Subject: DEVIATION REVIEW AND DECISION FORM

DEVIATION REVIEW AND DECISION FORM

Subdivision or Project Name: Winsome

Section of ECM from Which Deviation is Sought: Section 2.8.8.A. cul-de-sacs

#### PHASING TABLE

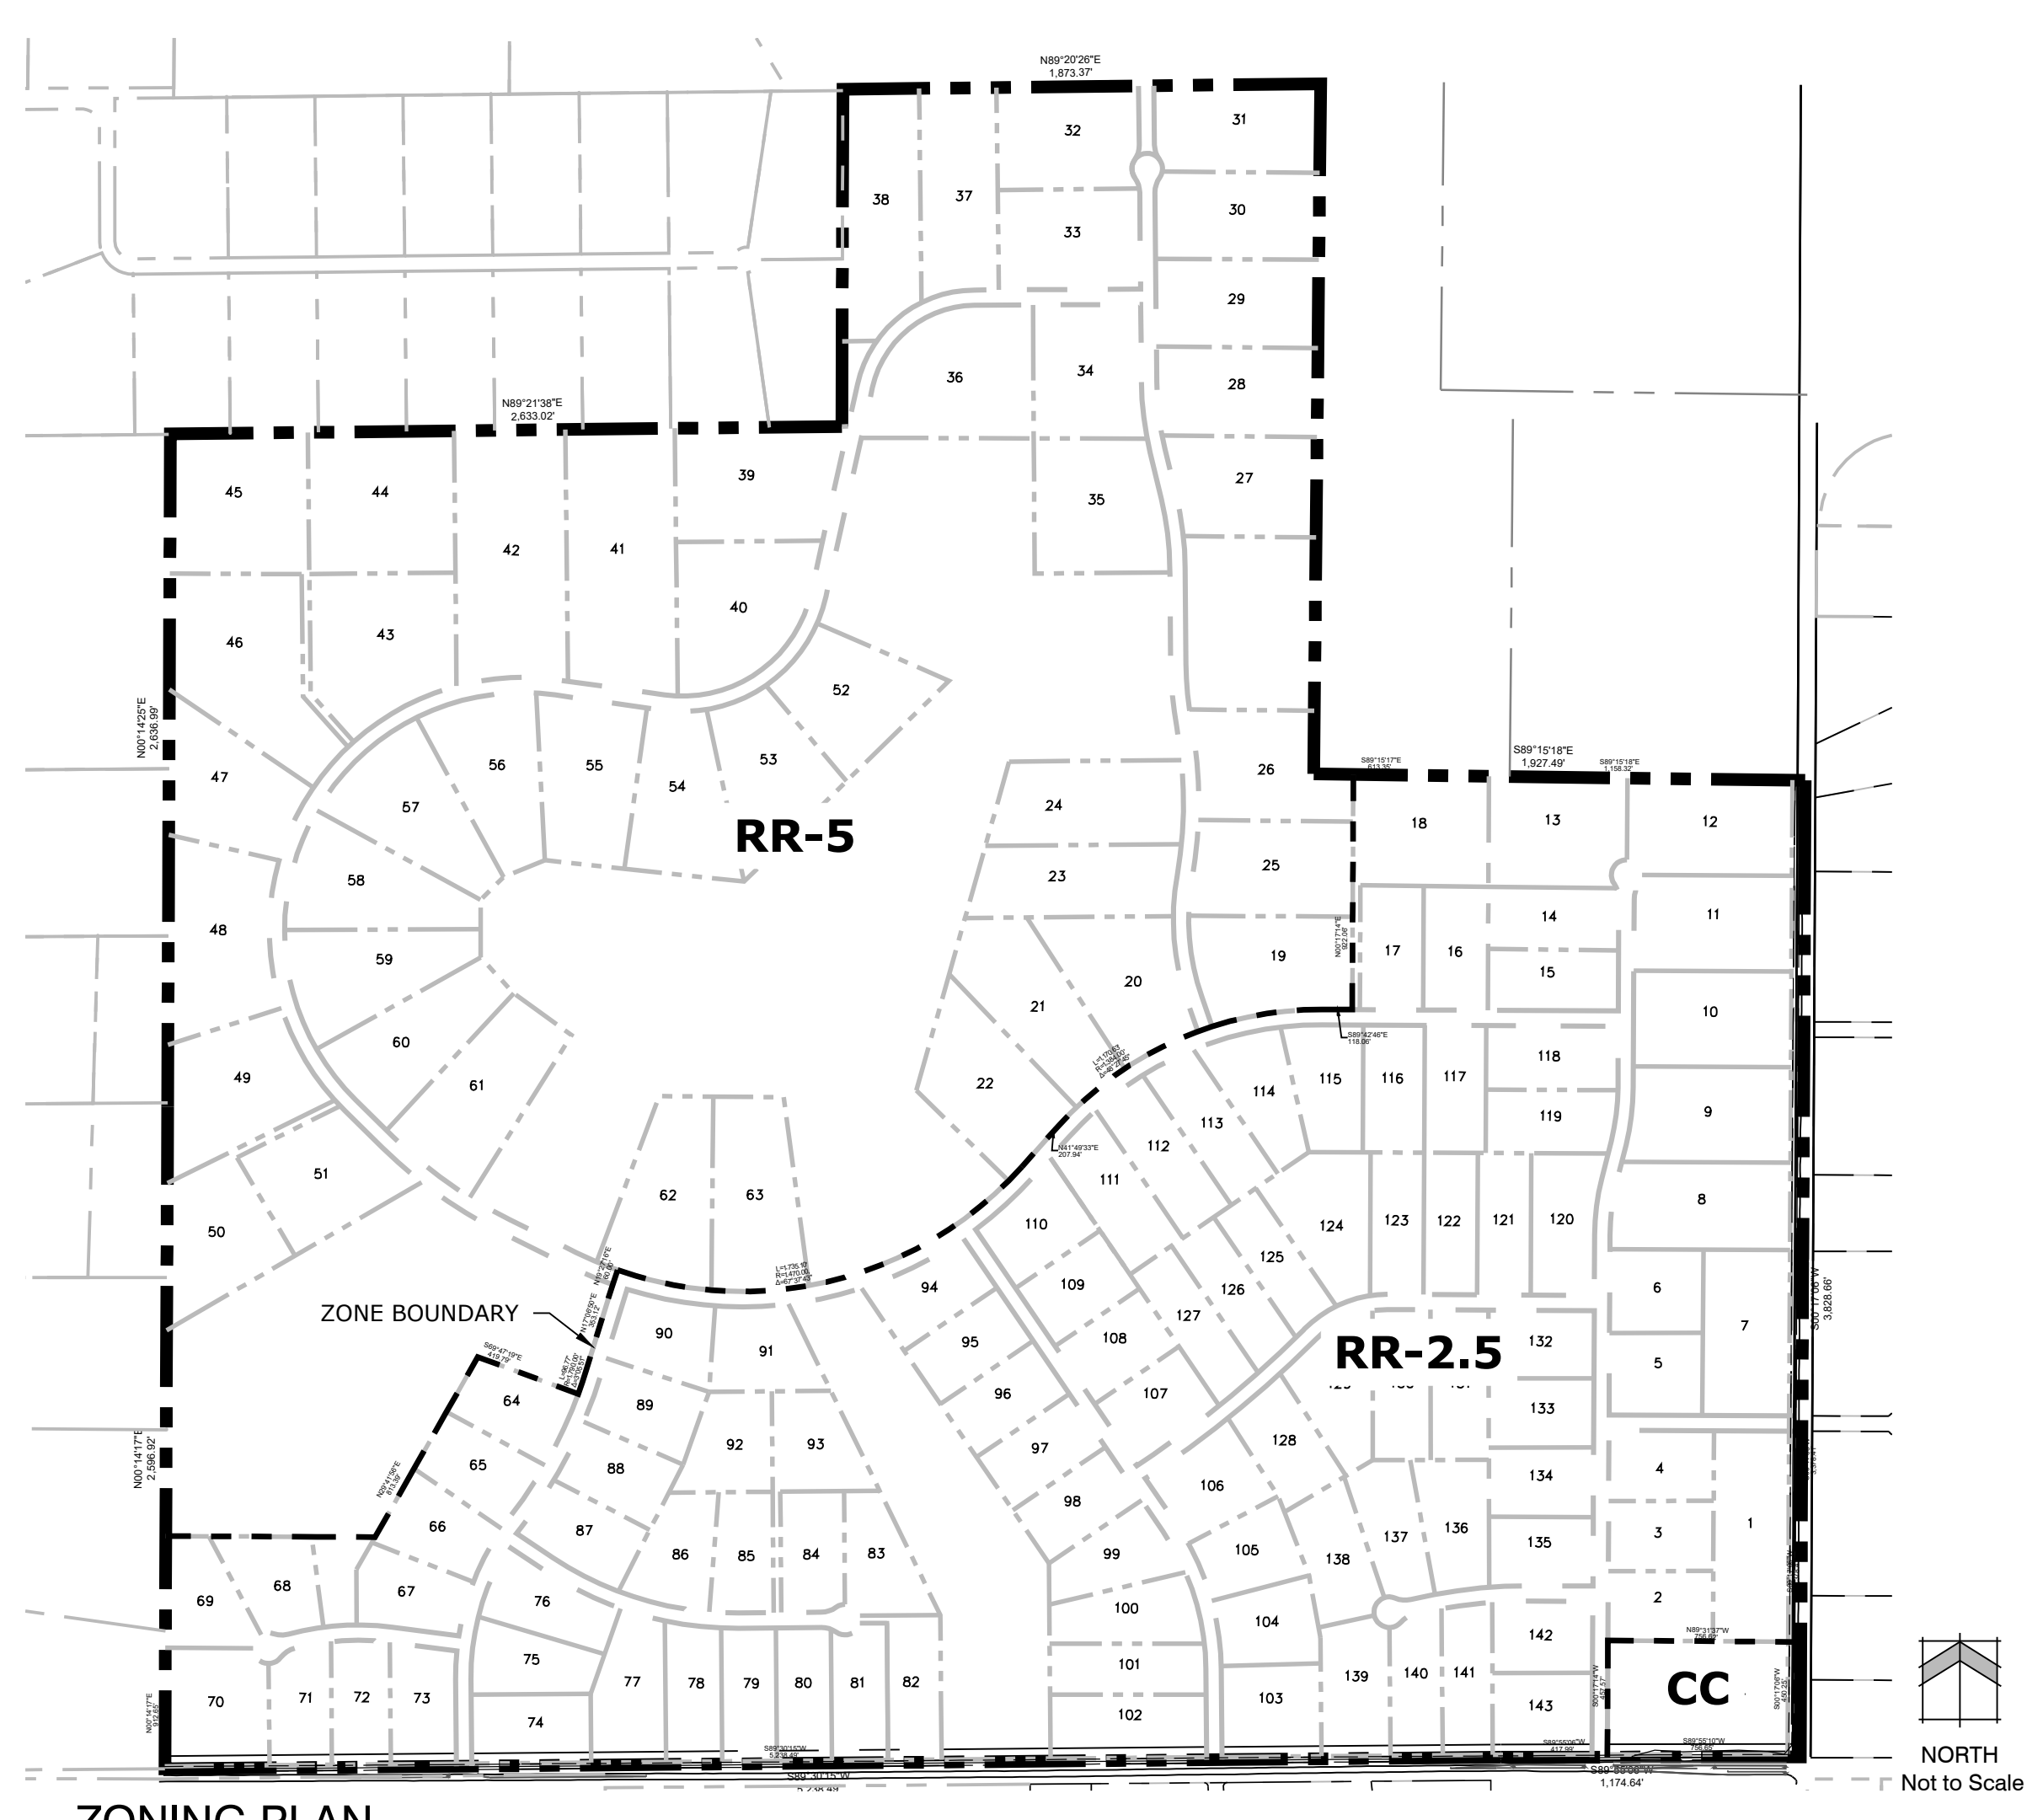
Note on the deviation request that a temporary cul-de-sac will be constructed.

Label the street and phasing this applies to.
